**DEVIATION REVIEW  
AND DECISION FORM**

**Deviation No. 4  
REV. 3-14-2019**

Subdivision or Project Name: Rollin' Ridge Estates

Proposed Nature and Extent of Deviation: Allow abbreviated (shorter than ECM standard) westbound left-turn lane and taper lengths on Hodgen Road at the Cherry Crossing Drive intersection.

Hodgen Road

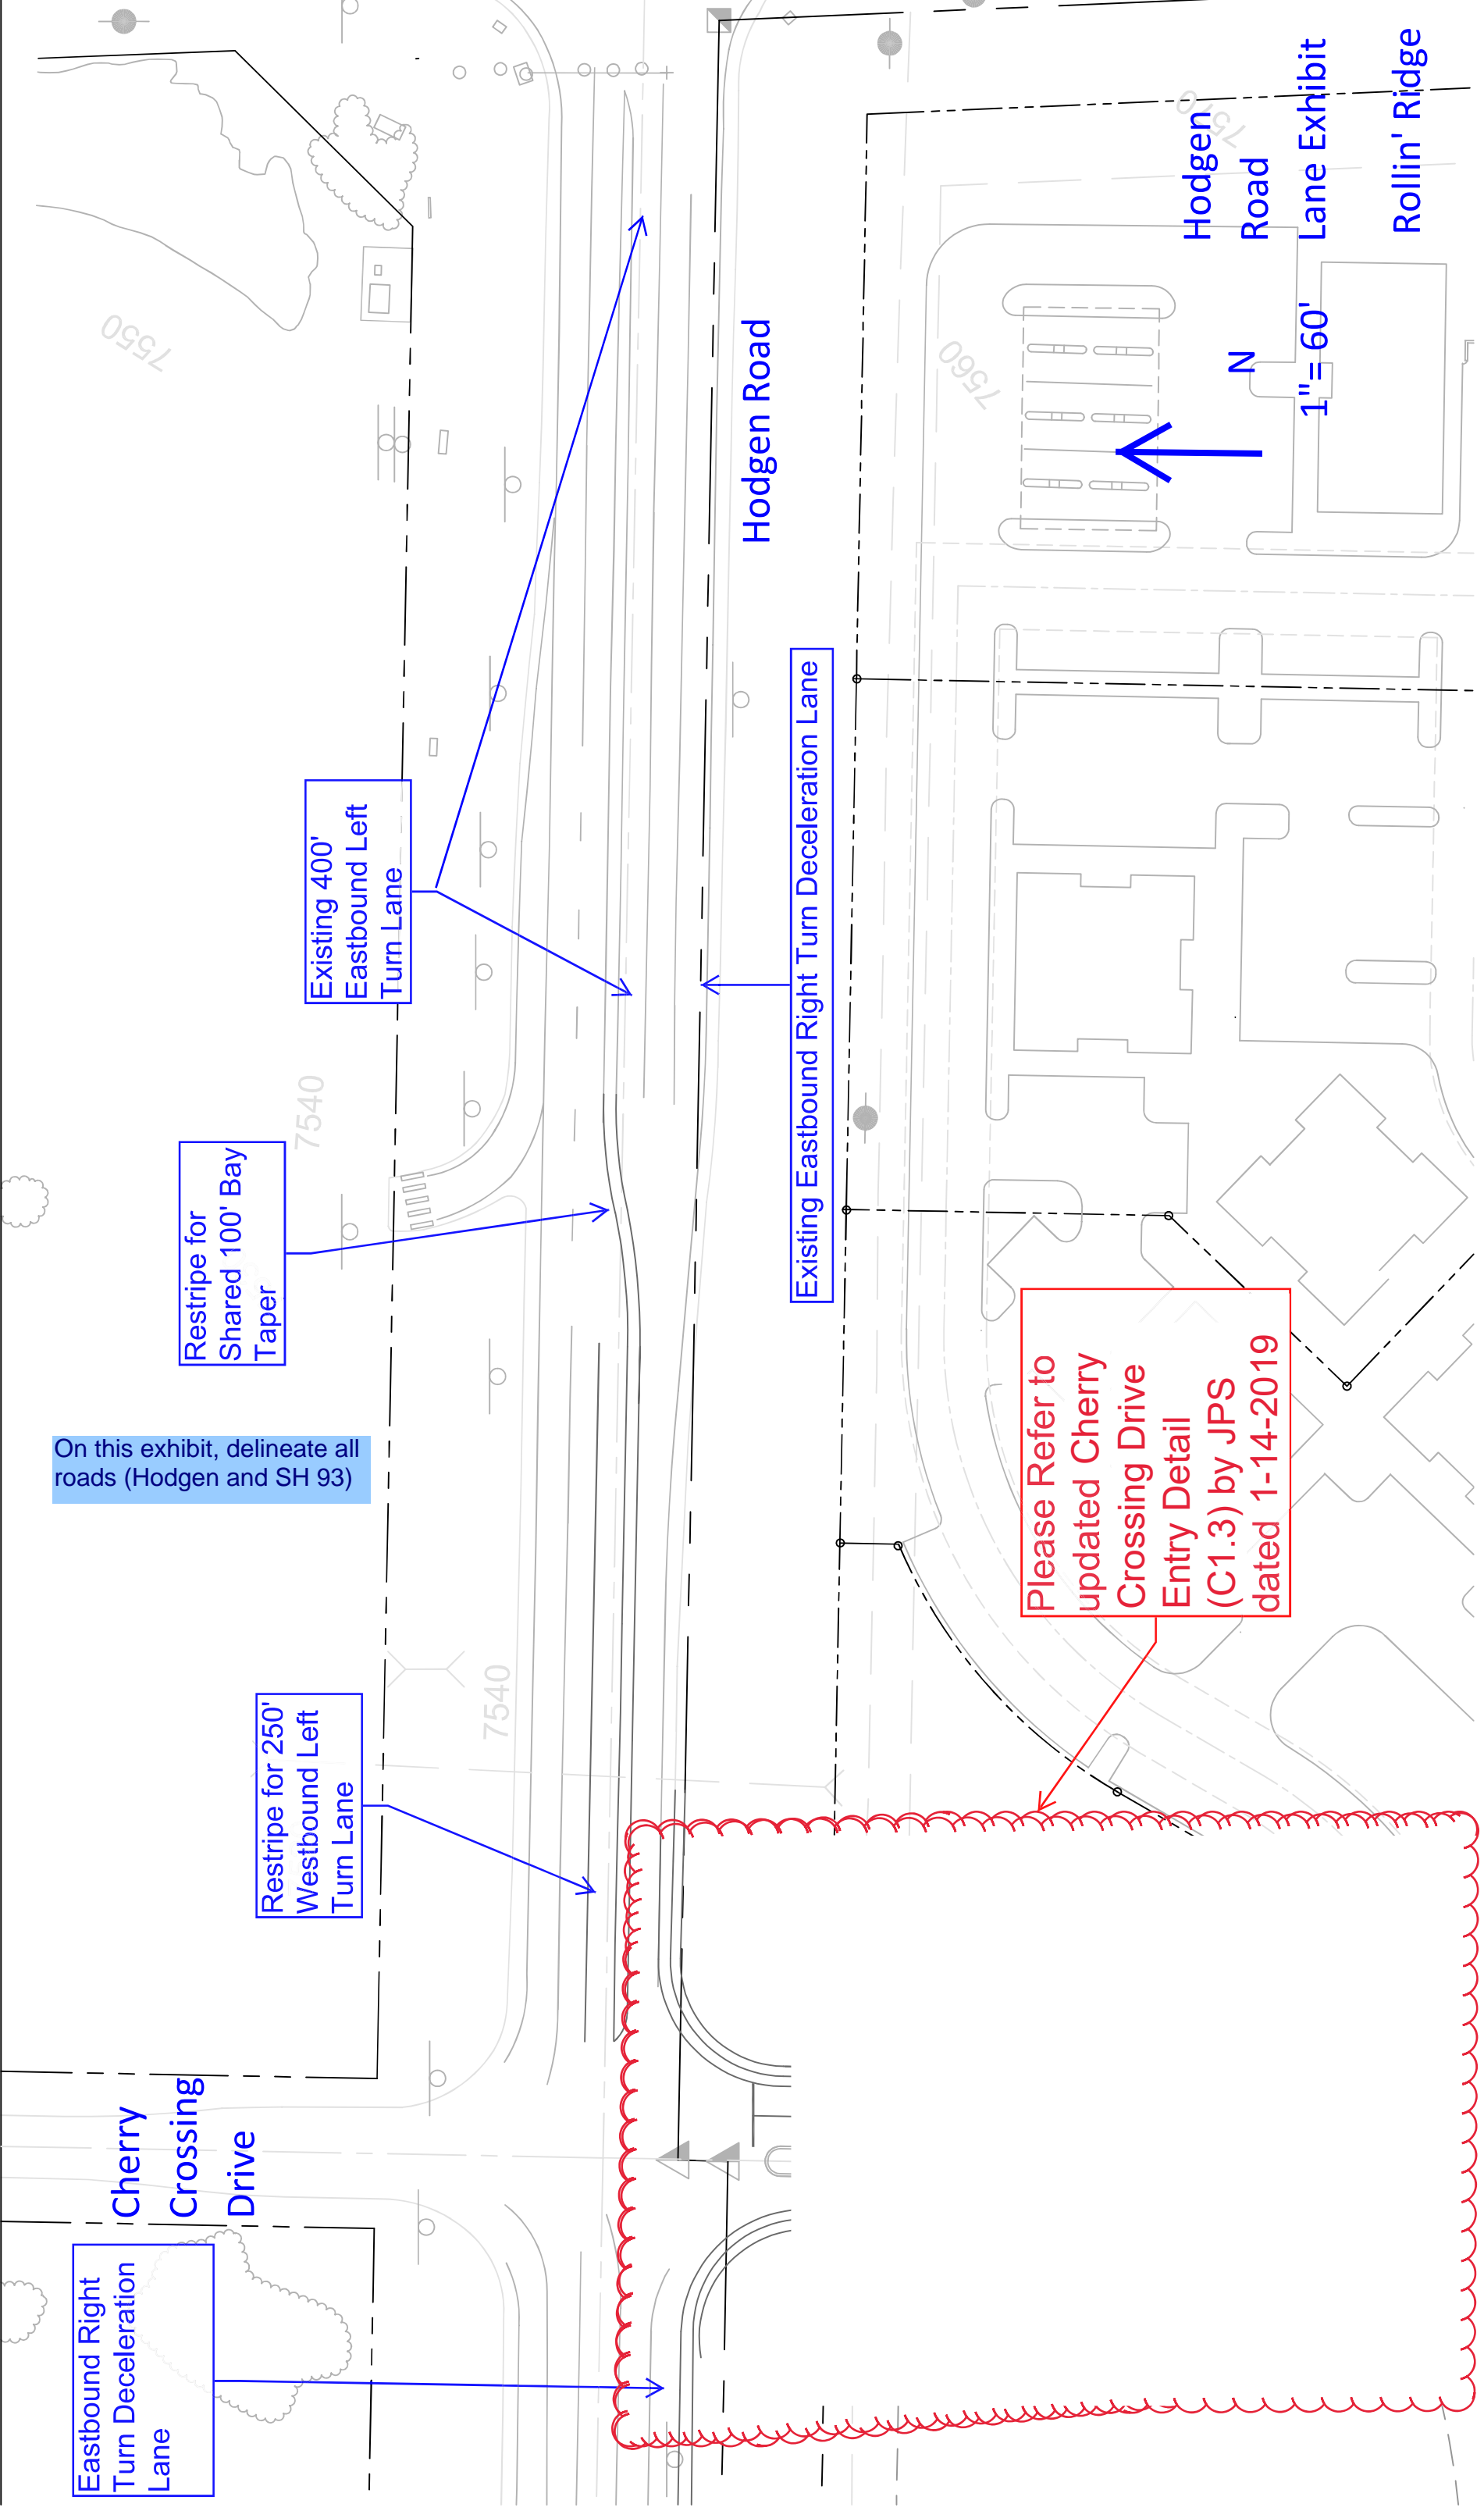
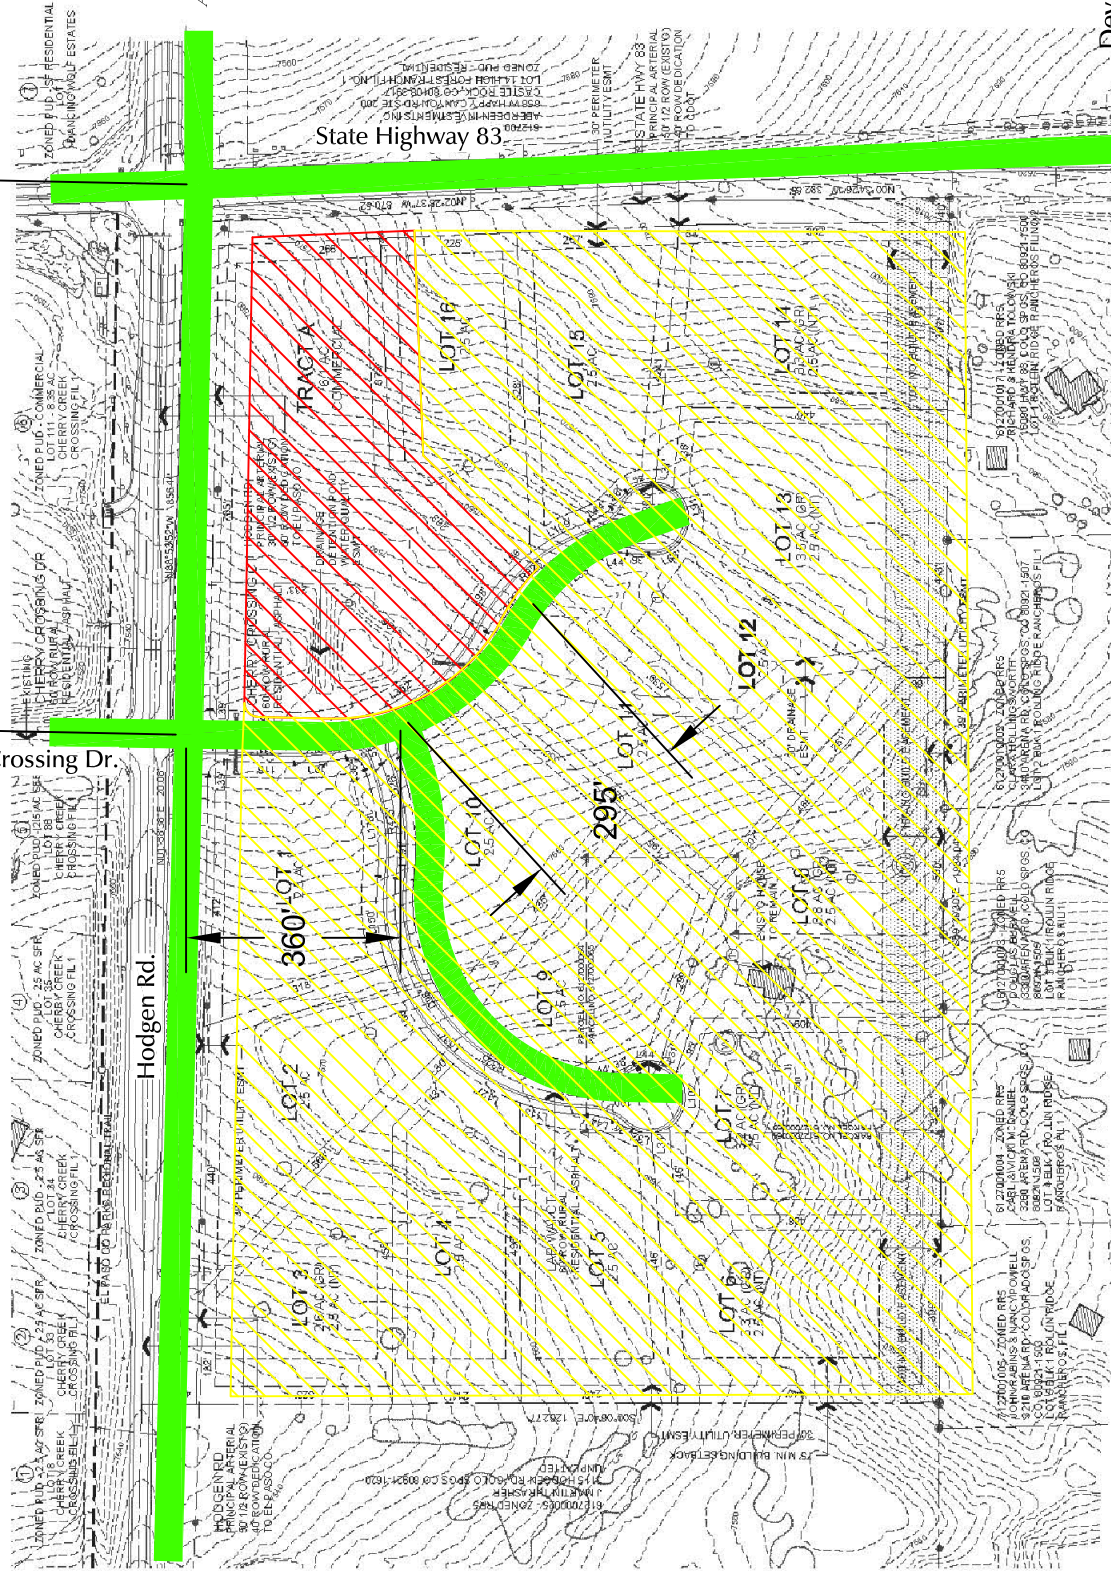
please provide an exhibit.

provide exhibit.
